RESPONSE TO SUBMISSIONS – SSD-80814238

ROAD 1 DATA CENTRE, 1-5 KHARTOUM ROAD, MACQUARIE PARK

### B99 VEHICLE SWEPT PATHS

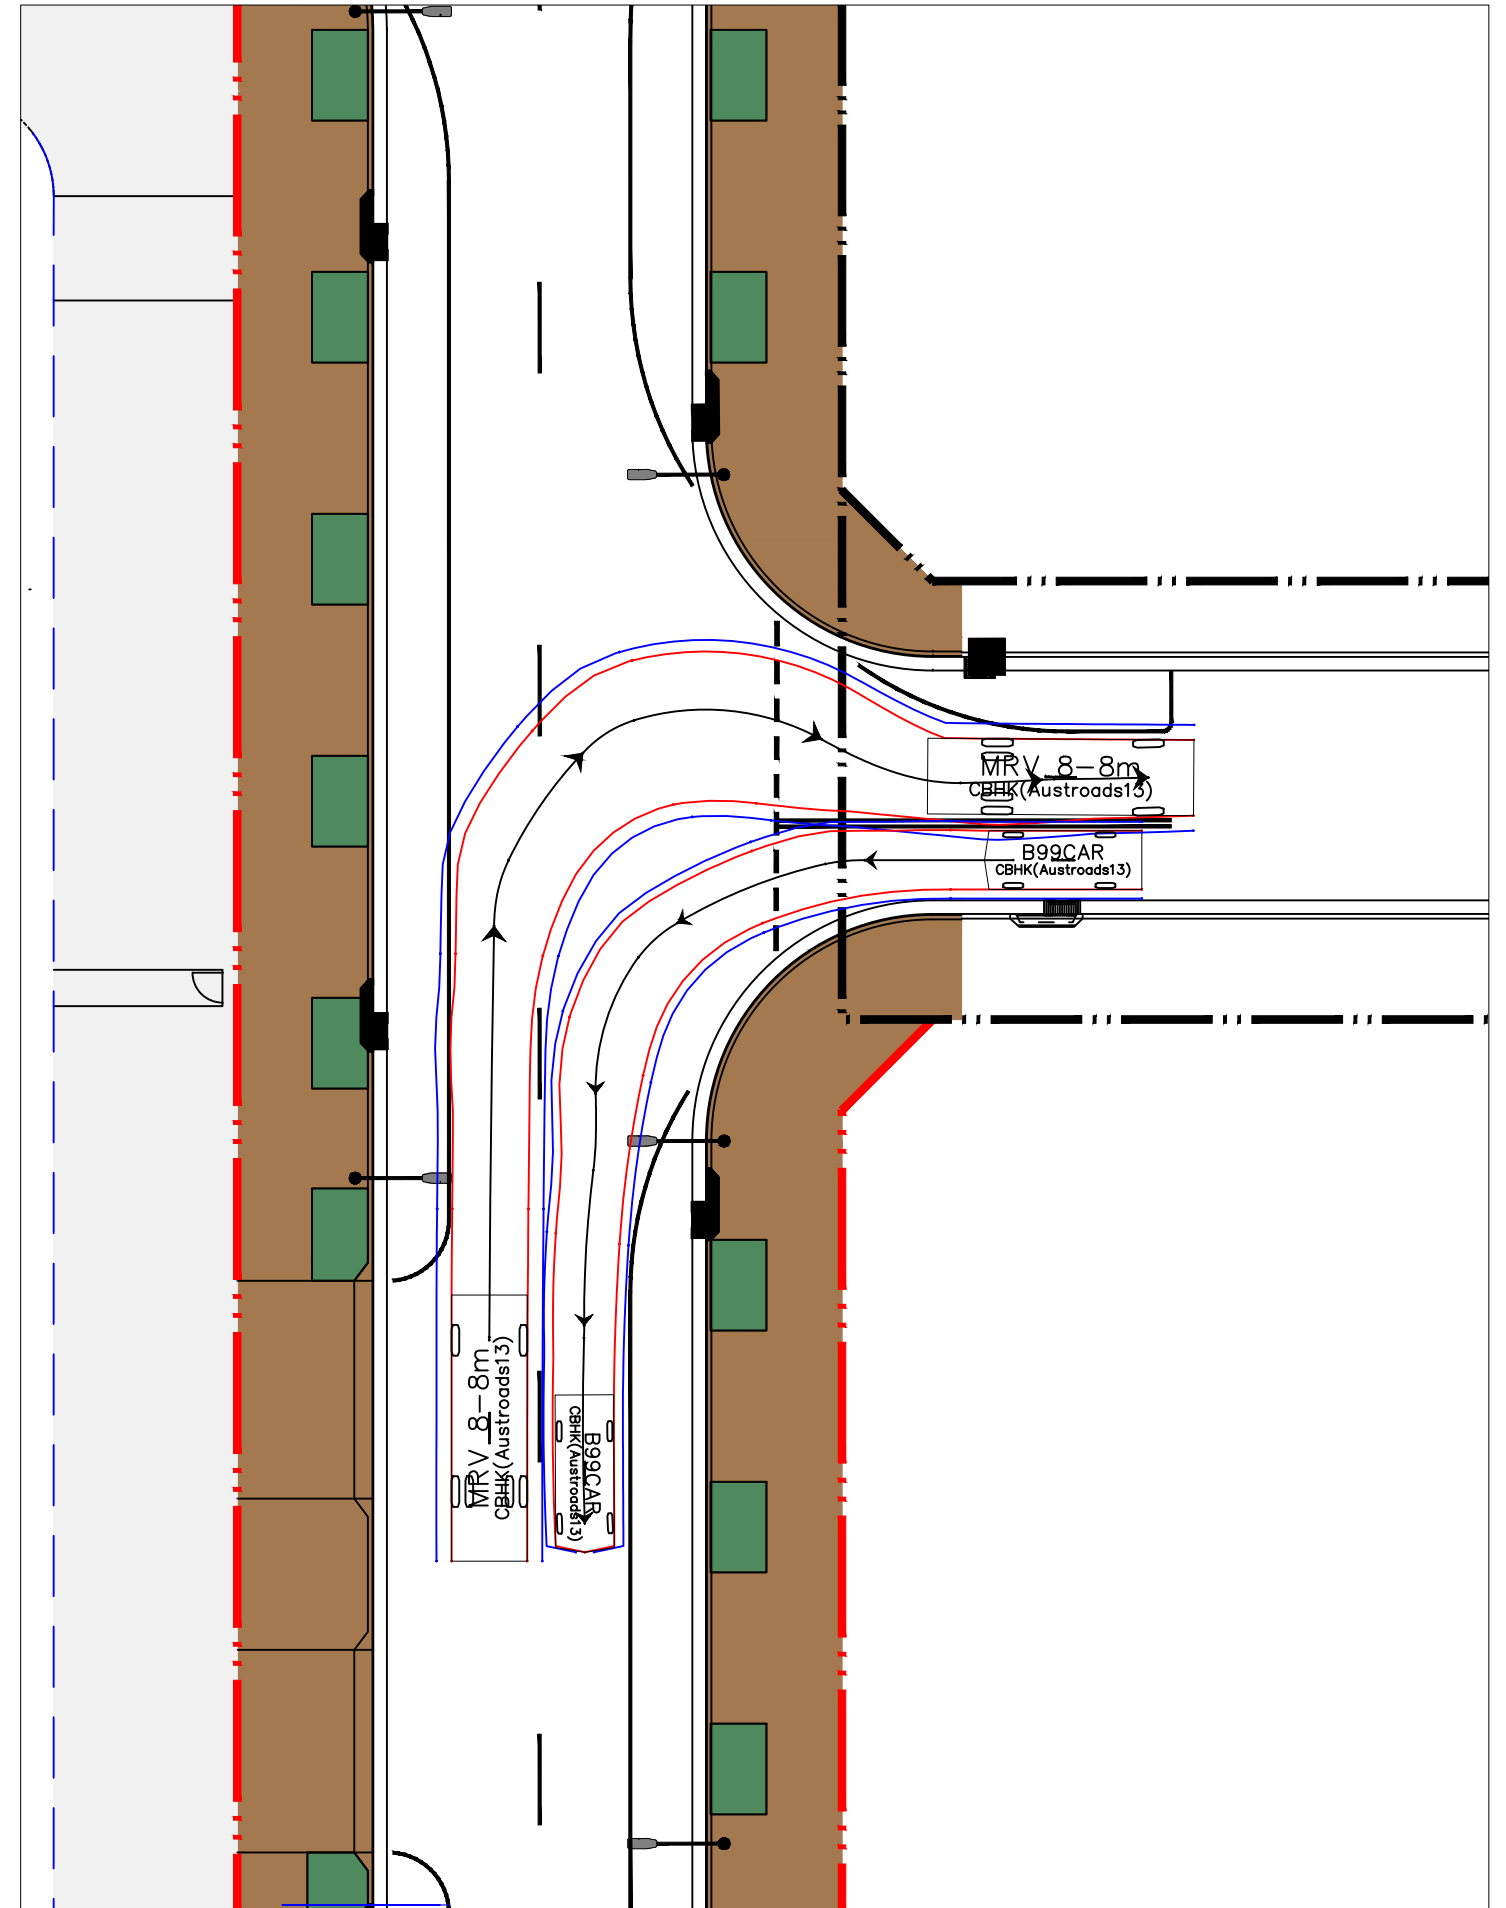
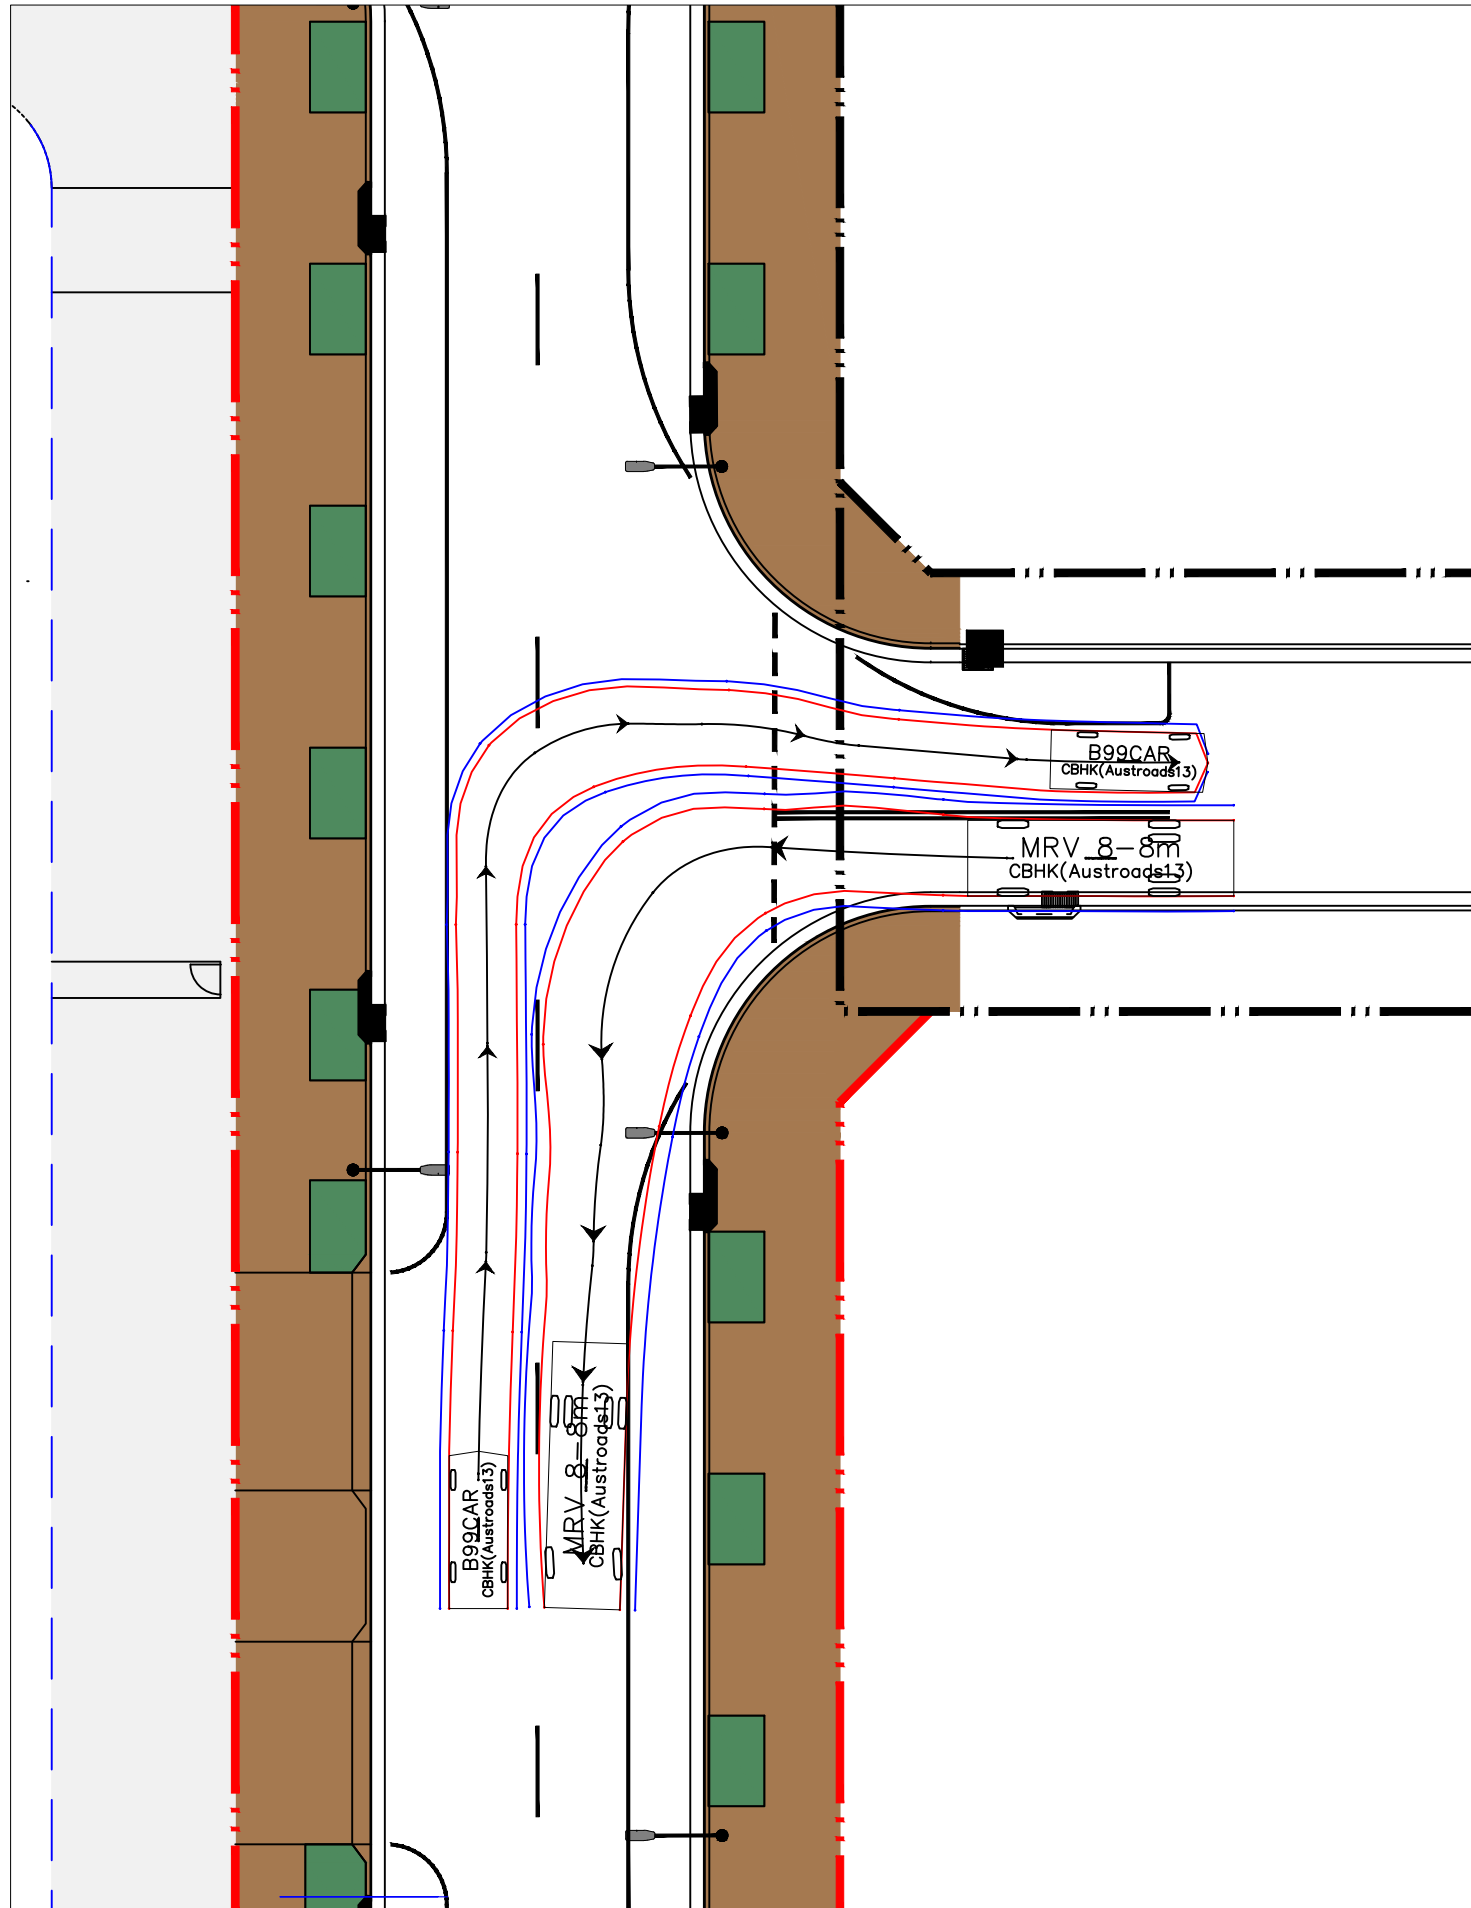
<p><u>Traffic and Parking</u></p> <p>Clarification is required as to why this proposed data centre does not require 19m/20m long trucks, which are typically proposed for each of other data centres in Macquarie Park. This clarification is requested to address potential future challenges related to operating 19m/20m long trucks at the site.</p> <p>It is requested that an estimate of truck trips be provided based on the site's operational and maintenance requirements and assess their impact on the local road network. Specify the largest truck size and include swept path analyses for inbound and outbound movements at the intersections of Talavera Rd/Road 22, Road 22/Road 1, ensuring a MRV can safely pass a B99 car, and at the site access driveway.</p>	<p>The proposed development comprises a data centre with four floors of technical data floor space (accommodating eight data houses) with a data hall GFA of approximately 6,572sqm. It is substantially smaller in scale compared to other neighbouring data centres in Macquarie Park. For this reason, the operational servicing requirements differ, and the data centre use does not necessitate regular 19m/20m truck movements.</p> <p>Day-to-day servicing will be undertaken by small to medium rigid vehicles up to 8.8m in length. The loading dock access driveway and on-site manoeuvring areas have been designed to ensure these service vehicles can enter and exit the site in a forward direction and without the need to queue or dwell on the adjacent road network. Based on the nature of the use, the proposed data centre is expected to generate low service vehicle volumes, typically two to three vehicle trips per day.</p>	Attachment C

Summary of Issue Raised	Response	Supporting Document
	<p>General maintenance activities, including delivery or replacement of diesel generators, will be very rare and infrequent. These activities may require large rigid trucks or 19m articulated vehicles. When such works are required, deliveries will occur under traffic management control, with a mobile crane positioned within the kerbside and northbound traffic lanes of Road 1 across the loading dock and car park access driveways. The crane will lift generators directly into the generator racking area within the building. These works will be subject to a standard application to City of Ryde and supported by a detailed traffic management plan.</p> <p>Regarding intersection performance, the Talavera Road and Road 22 intersection was designed and constructed as part of the completed data centre at 8 Murrell Street, Macquarie Park. Council approved this intersection on 16 May 2022 in conjunction with the endorsed design for Road 22. Swept path analyses for an MRV, B99 car, and relevant design vehicles at Talavera Road/Road 22, Road 22/Road 1, and the site driveway have been prepared and are included in Attachment C.</p>
